SF17/23552
MP05_0024 MOD 3

**RE: Notification of Modification
Dolphin Point Residential Subdivision (MP 05_0024 MOD 3)**

Figure 2 - The original and revised location of Scrape Sites 4A, 4B, 5A and 5B (source: allen price & scarratts)

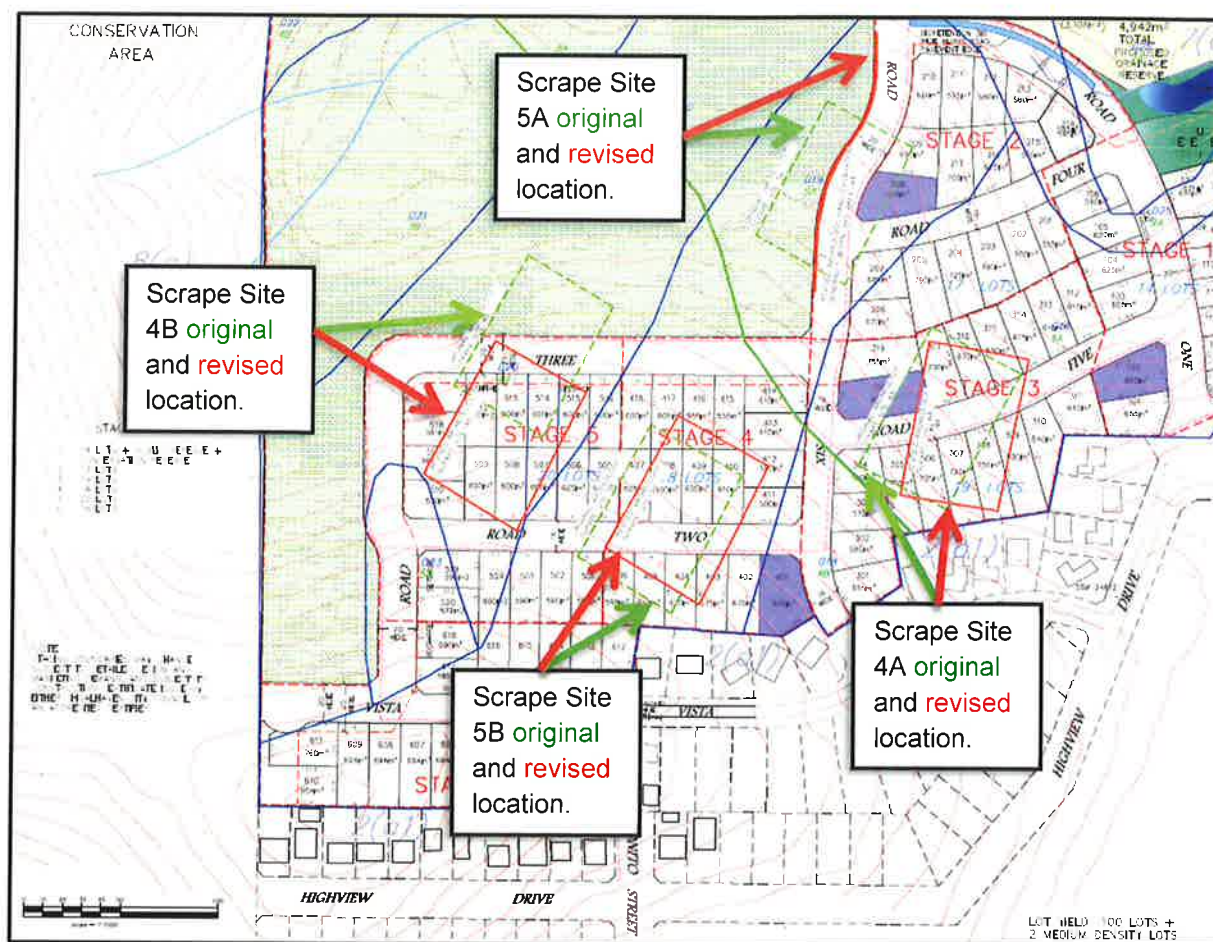
- A threshold of approximately 20% of the context being developed appears to have been used to determine whether broad area hand excavation occurred in Stages 2-4 (Kuskie 2005, p.149). The proposed development footprint appears to show that more than 20% of 4B and 5A will be impacted under the proposed subdivision layout. This supports retaining salvage excavation at locations 4B and 5A.

Given the above, the archaeological salvage at 4B and 5A can and should still occur. However, if there is to be any modification, we recommend that DPE as the consent authority relocate both salvage locations so that each location is entirely within the construction footprint while remaining within the respective landscape contexts.

- Figure 1 of the revised AHMP (Malbec, 2016, p.17) should be revised to show new locations for archaeological salvage within landscape contexts 4B and 5A. These new locations must be entirely within the construction footprint and consistent in size with the salvage area shown in the existing AHMP (Malbec 2007).
